Our ref: HA/2021/123193/01-L01
Your ref: BN/54/21/DOC
Date: 25 May 2021

APPROVAL OF DETAILS RESERVED BY CONDITION IMPOSED UNDER REF BN/50/20/PL RELATING TO CONDITION NOS 5 - MITIGATION METHOD STATEMENT, 6 - ARCHEALOGY, 7 - PILING RISK ASSESSMENT & METHOD STATEMENT, 8 - CONSTRUCTION & ENVIRONMENTAL MANAGEMENT PLAN, 9 - FOUL DRAINAGE, 10 - SURFACE WATER DRAINAGE, 11 - MAINTENANCE & MANAGEMENT OF SURFACE WATER DRAINAGE, 13 - PRE-COMMENCEMENT SITE MEETING, 15 - ODOUR ASSESSMENT OR EVIDENCE THAT LIVERY HAS CEASED, 16 - SOIL RESOURCE PLAN, 17 - LANDSCAPING, 18 - SCREEN WALLS & FENCES, 19 - ELEVATION DETAILS OF 2 PROPOSED COMMUNAL BIN STORES AND 20 - COLOUR SCHEDULE OF MATERIALS & FINISHES.

LAND WEST OF FONTWELL AVENUE FONTWELL AVENUE EASTERGATE PO20 3RX

Figure 3: Typical infiltration trench system detail

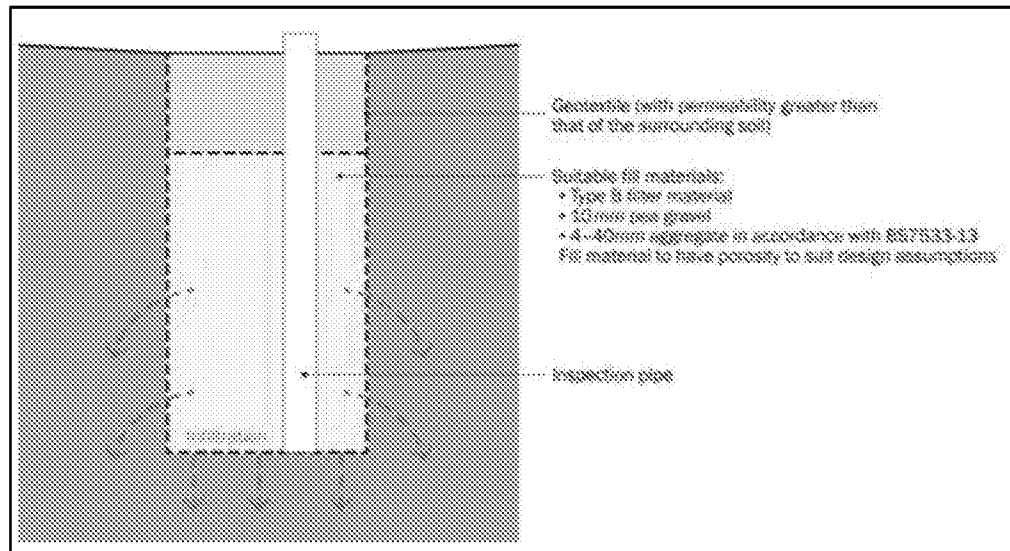
We have reviewed the SUDS Management and Maintenance Strategy and support the use of the SUDS CIRIA Manual and simple index approach to pollution prevention. The design drawings provided indicate that maximum depth of the infiltration trenches is 1.2m and therefore they do not penetrate the chalk.

We **recommend** the discharge of **condition 10**.
